**Marist Catholic College North Shore (SSD-10473)
Response to Submissions**

ATTACHMENT 1

Drawing No. DA-210	Issue D
Scale 1 : 200	Drawing Size A1
Project No. 18165	Drawn By BE

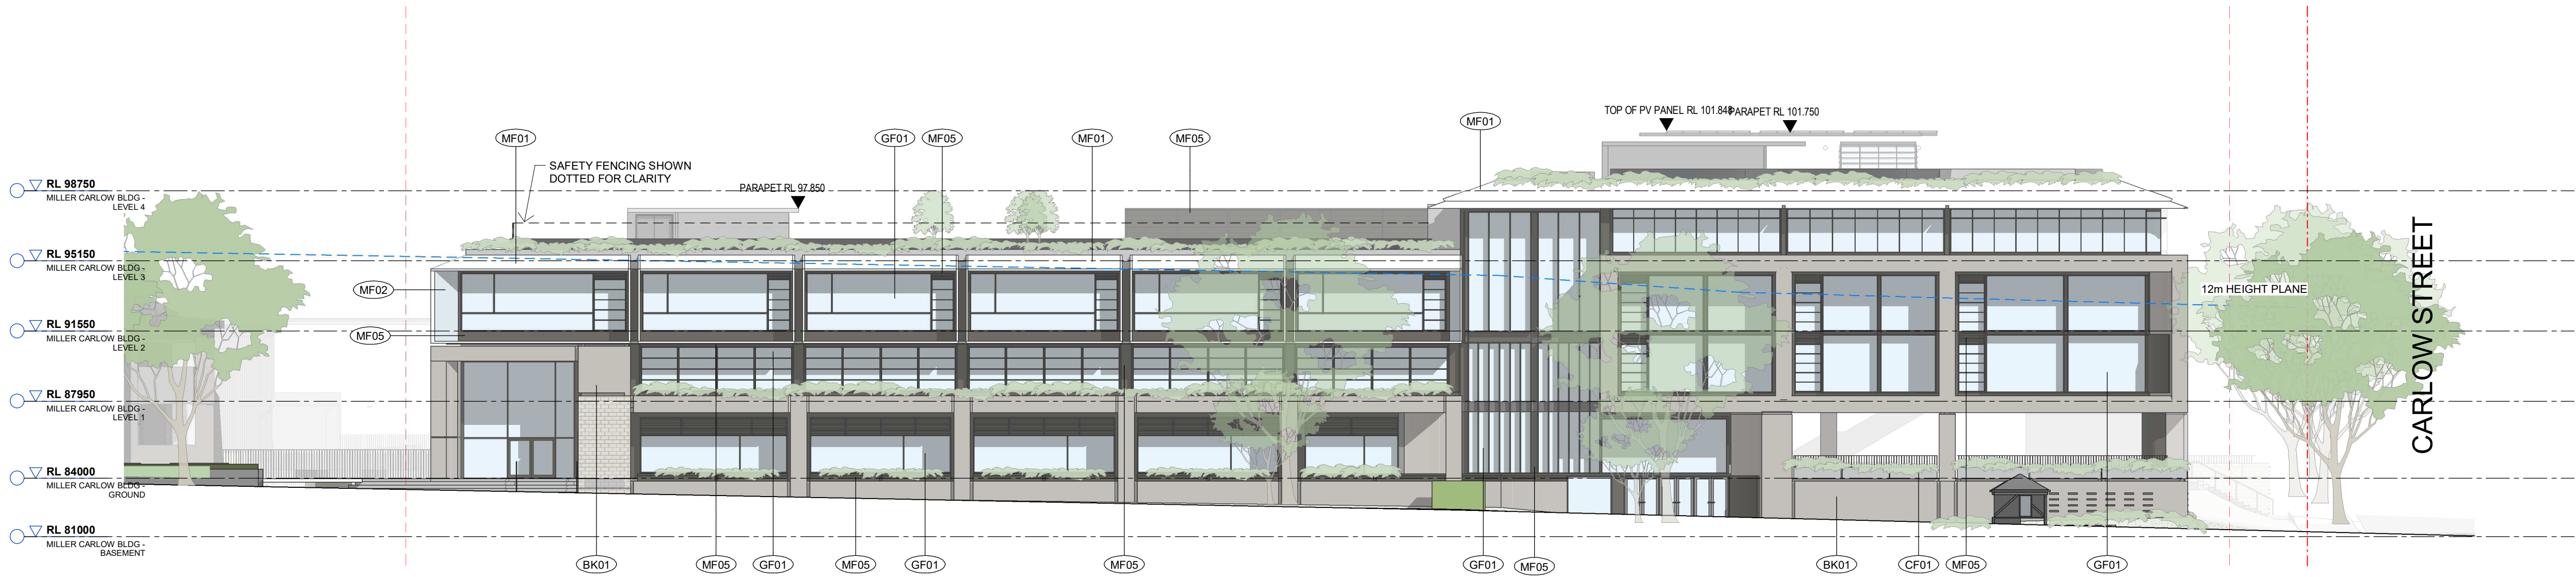
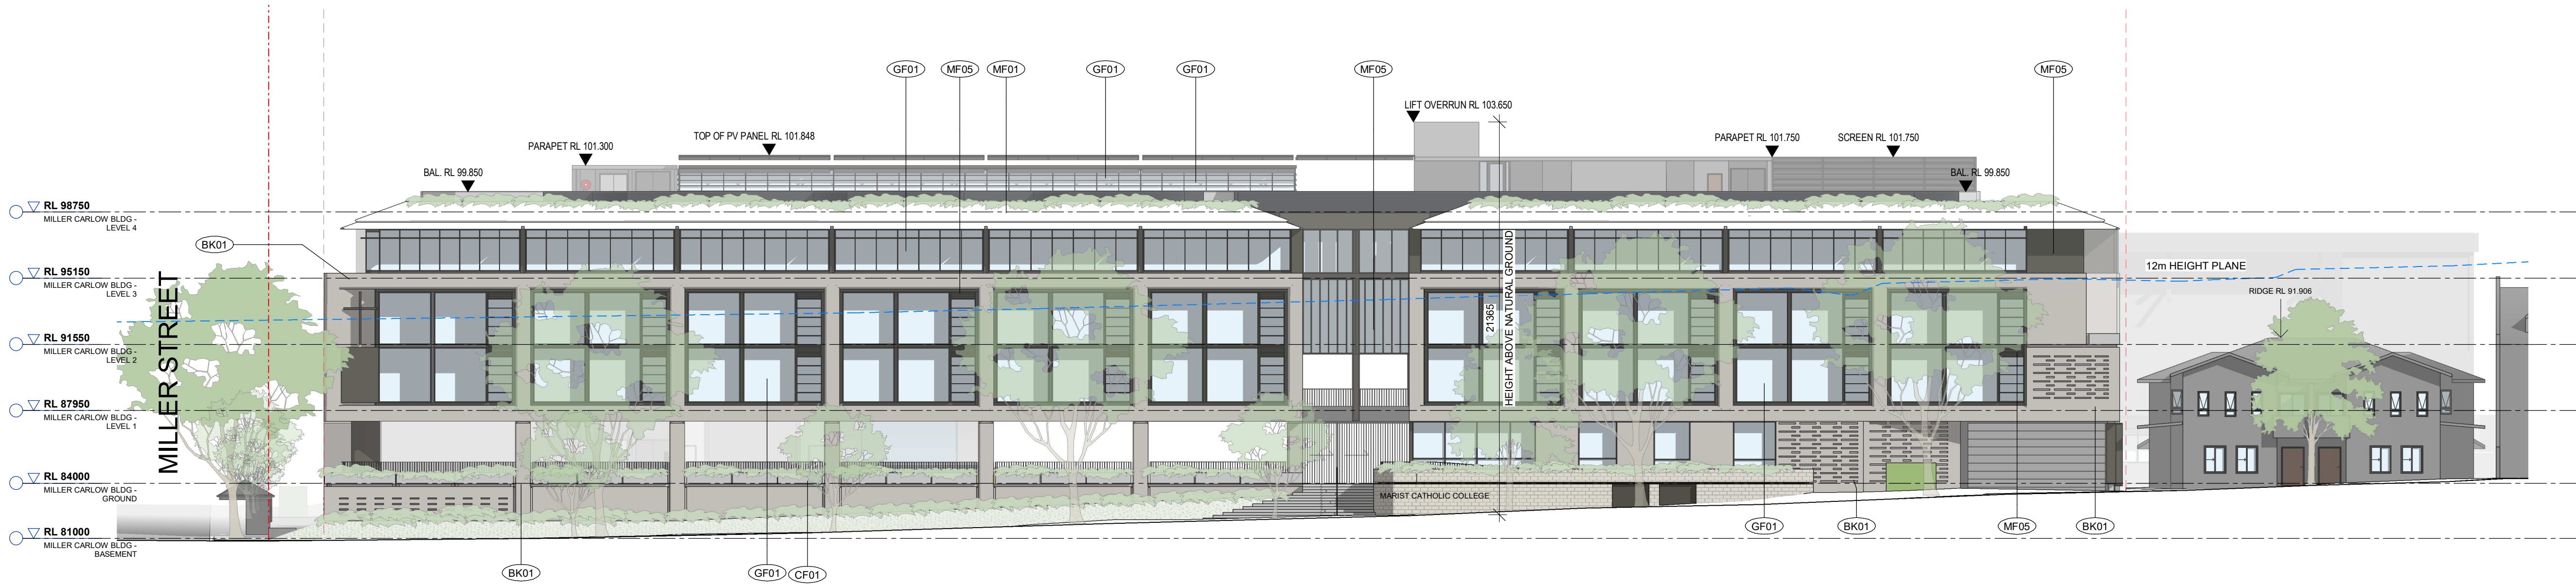
- the bulk and scale of the building at the corner of Miller and Carlow Street has not been assessed. The Department has raised this concern earlier and considers that the scale of the proposal at this corner should be reduced. The design should be revisited with the goal of being able to provide a proposed corner building of a form, that more sympathetically responds to the heritage aspects of the surrounding context.

Drawing No. DA-225	Issue A
Scale 1 : 100	Drawing Size A1
Project No. 18165	Drawn By BE

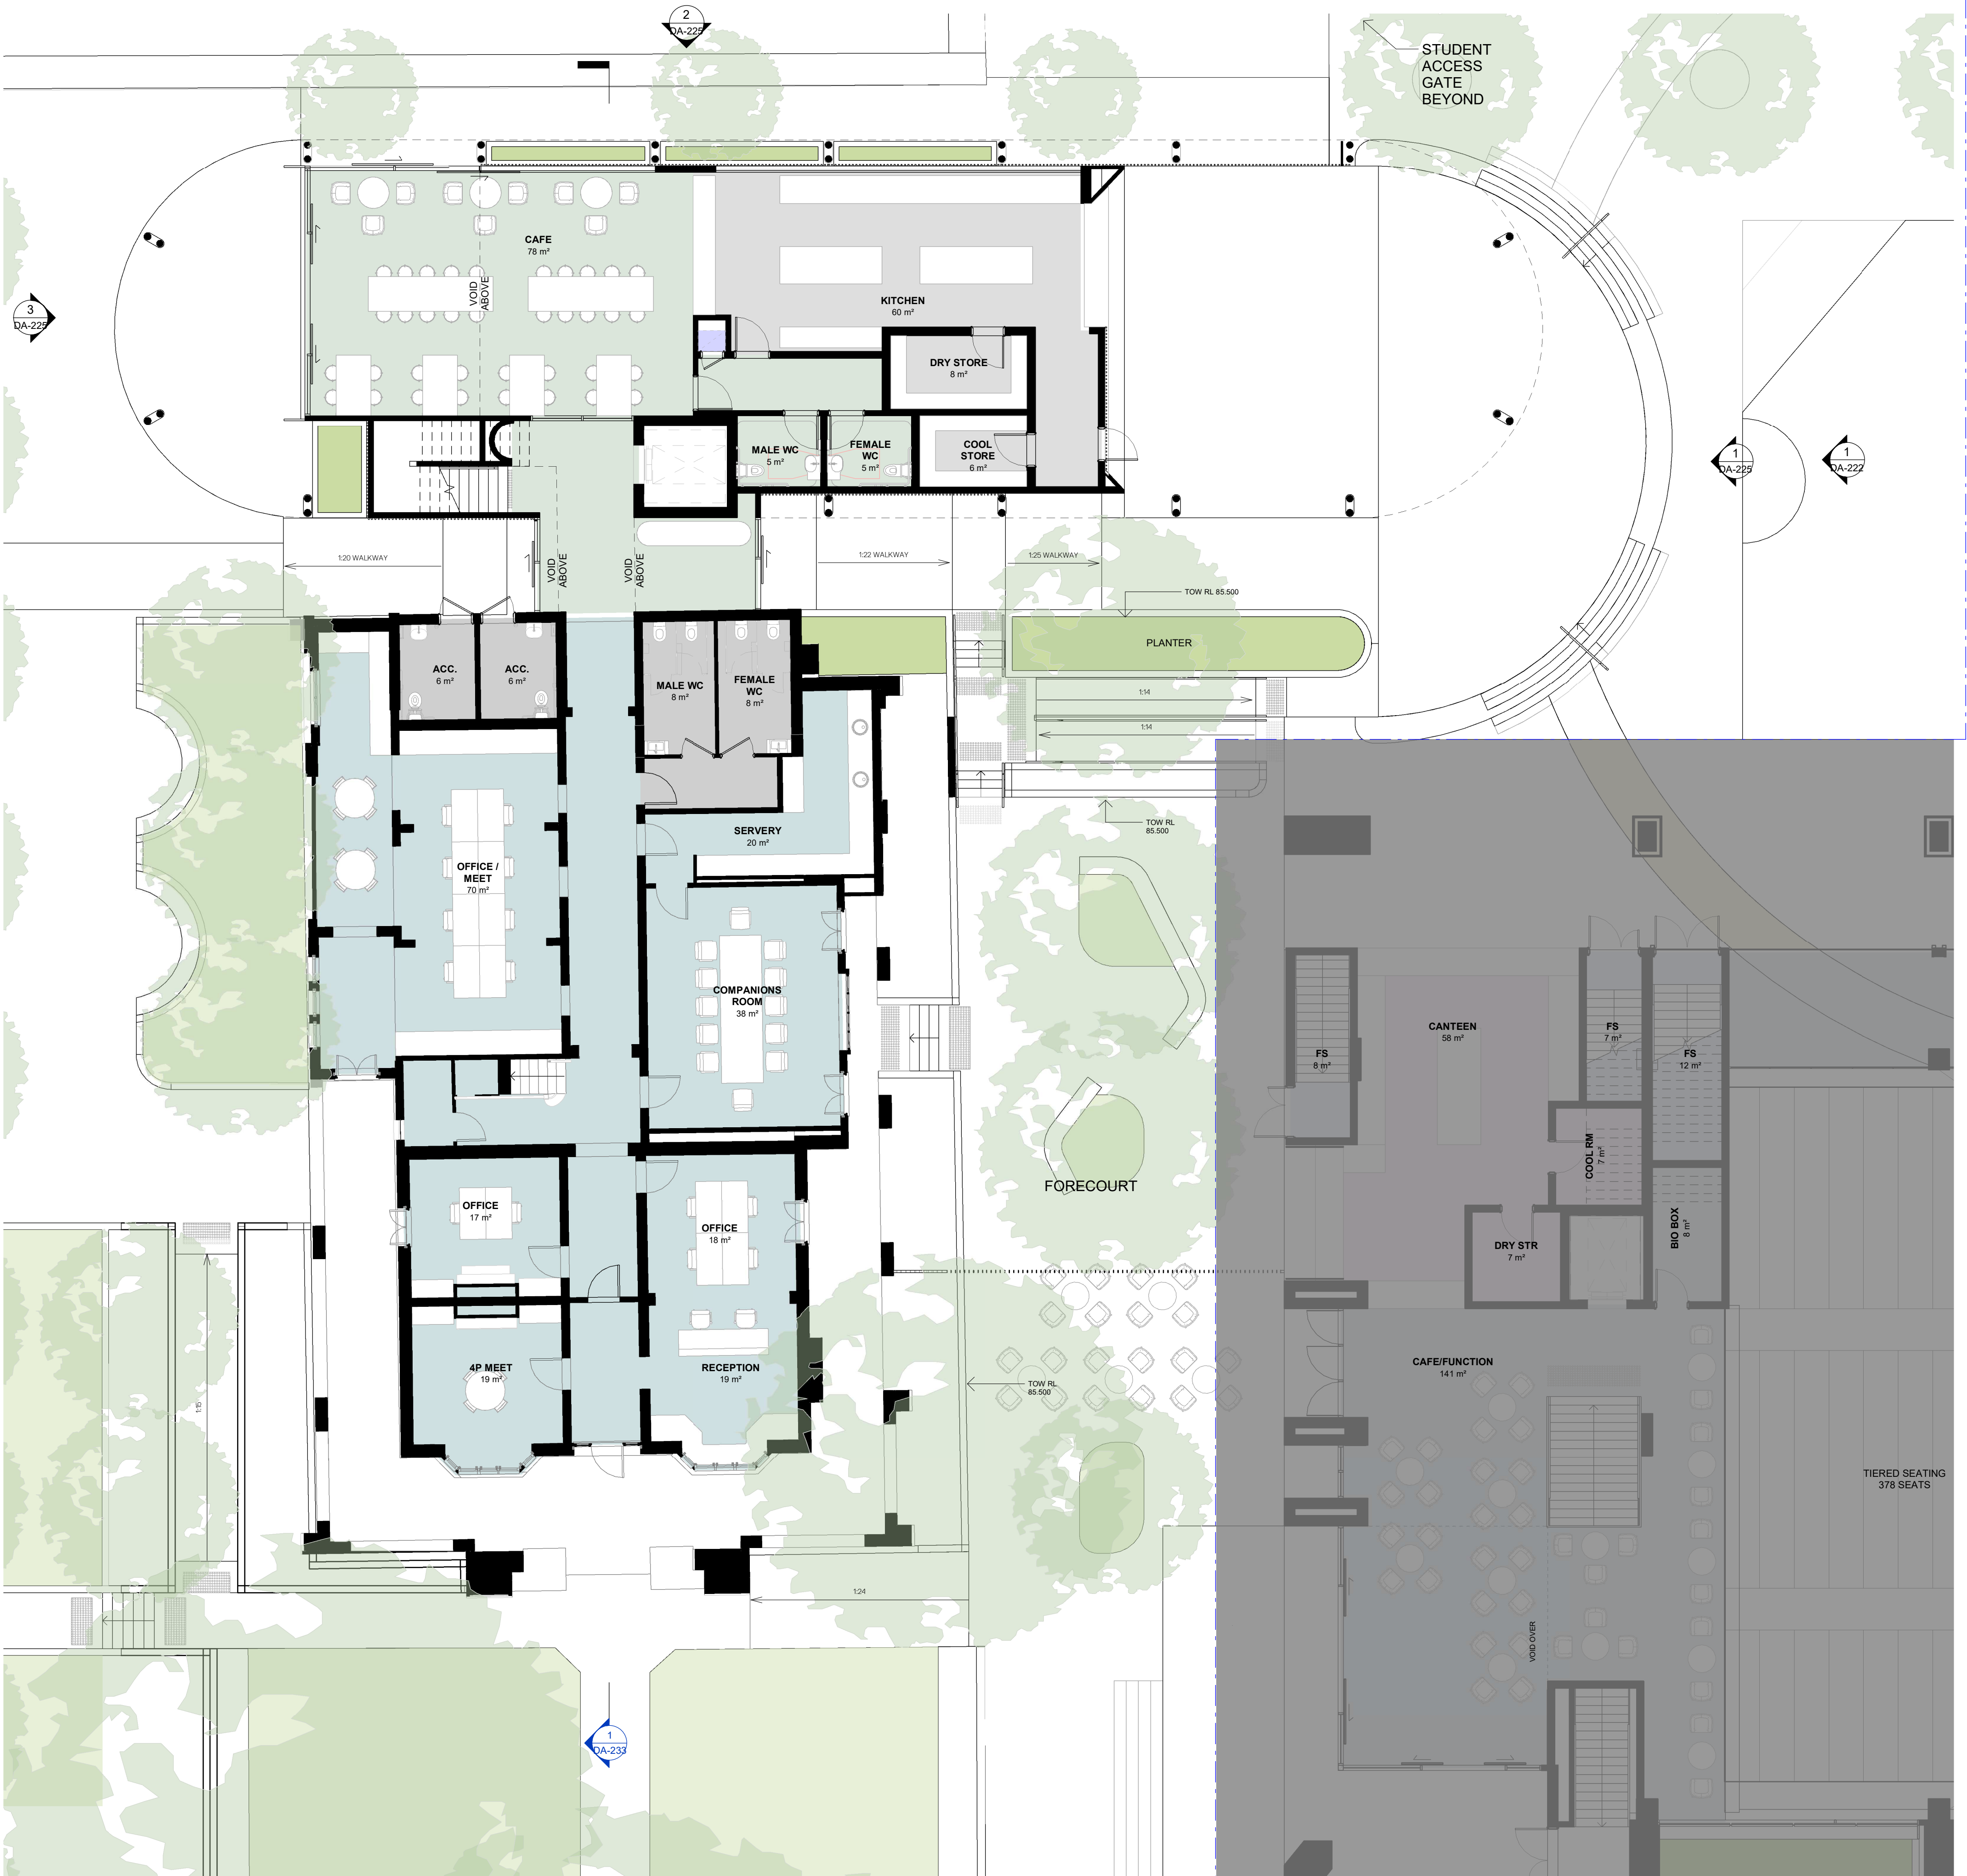
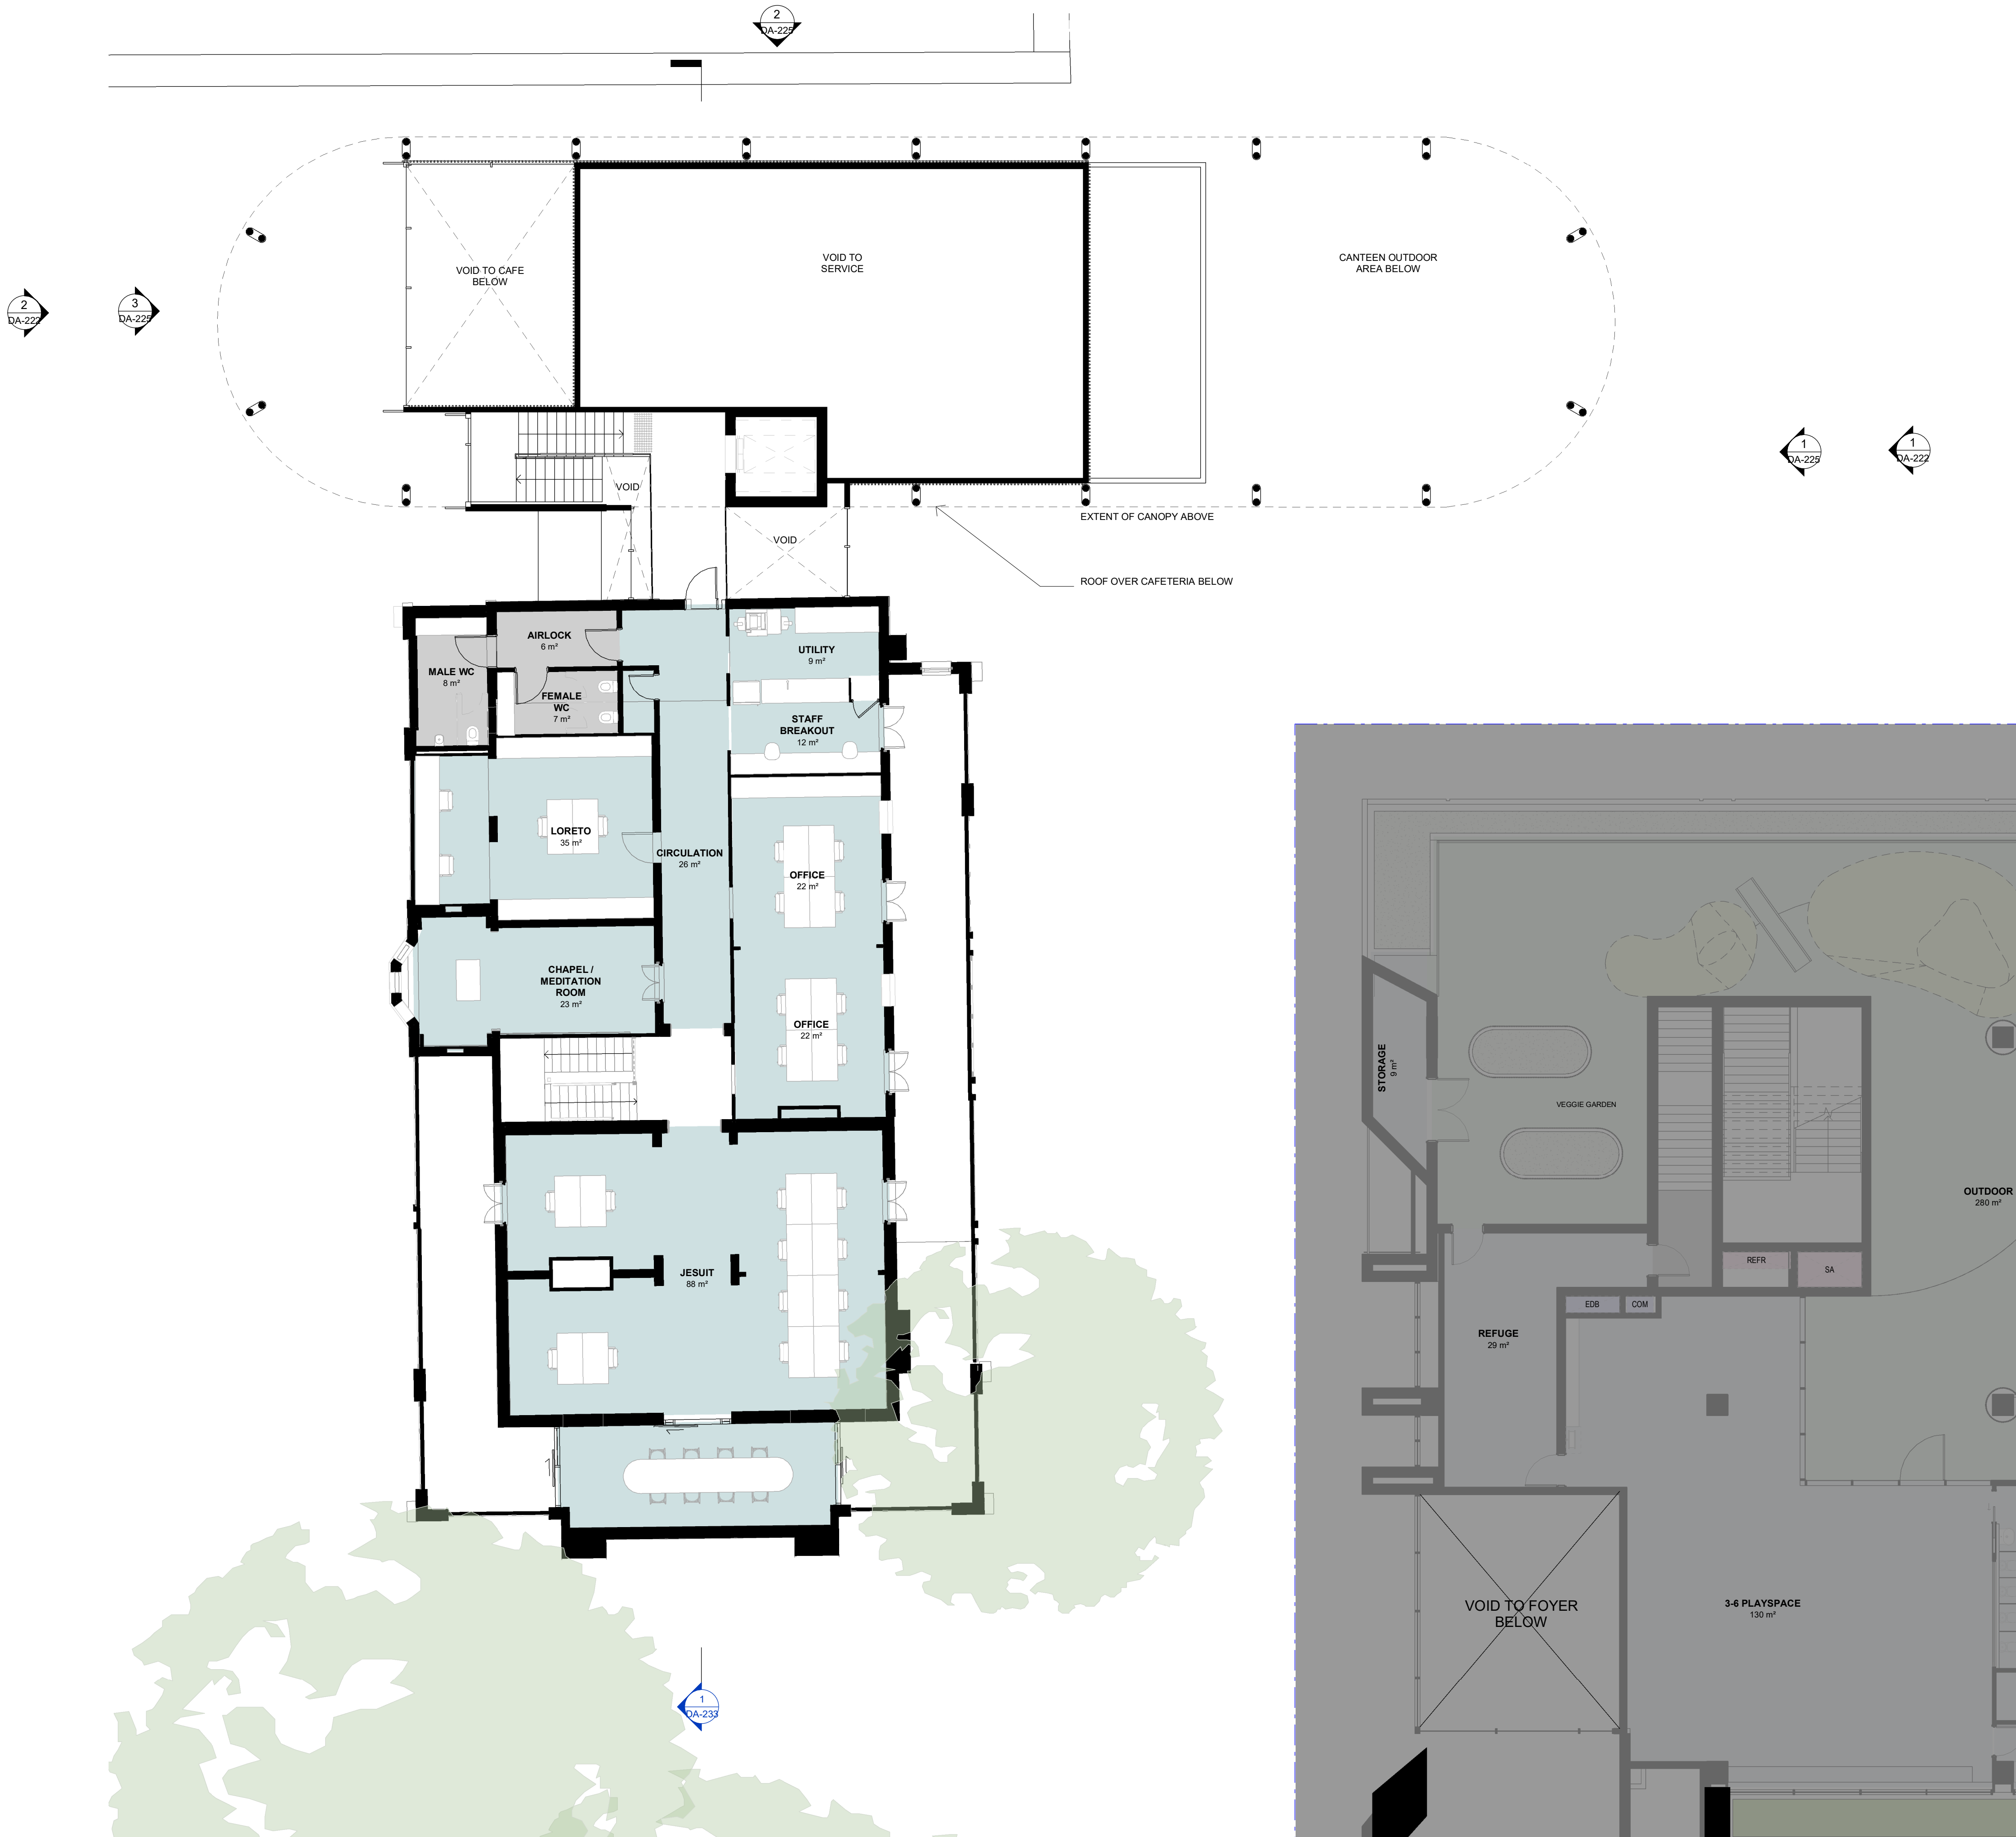
- the setting and curtilage of the church group is not identified or described in the HIS, nor is there adequate analysis of the proposed impact of landscaping on the setting and relationships of the group. This is required to be addressed. More detail of the proposed café/canteen building is required to understand any potential heritage impacts on the appreciation of the Presbytery and setting of the church group.

- correctly show the 6 parking spaces adjacent to St Mary's Church as accessible spaces (currently shown as 7 standard parking spaces).
- include elevational / sectional drawings showing the amendments to the Ron Dyer Centre and Presbytery and the proposed 2 storey pavilion building.
- include new and updated computer generate imagery (CGIs) including:
 - new CGI imagery taken from within the site to demonstrate the proposed changes - particularly showing the new courtyard north of the Church,
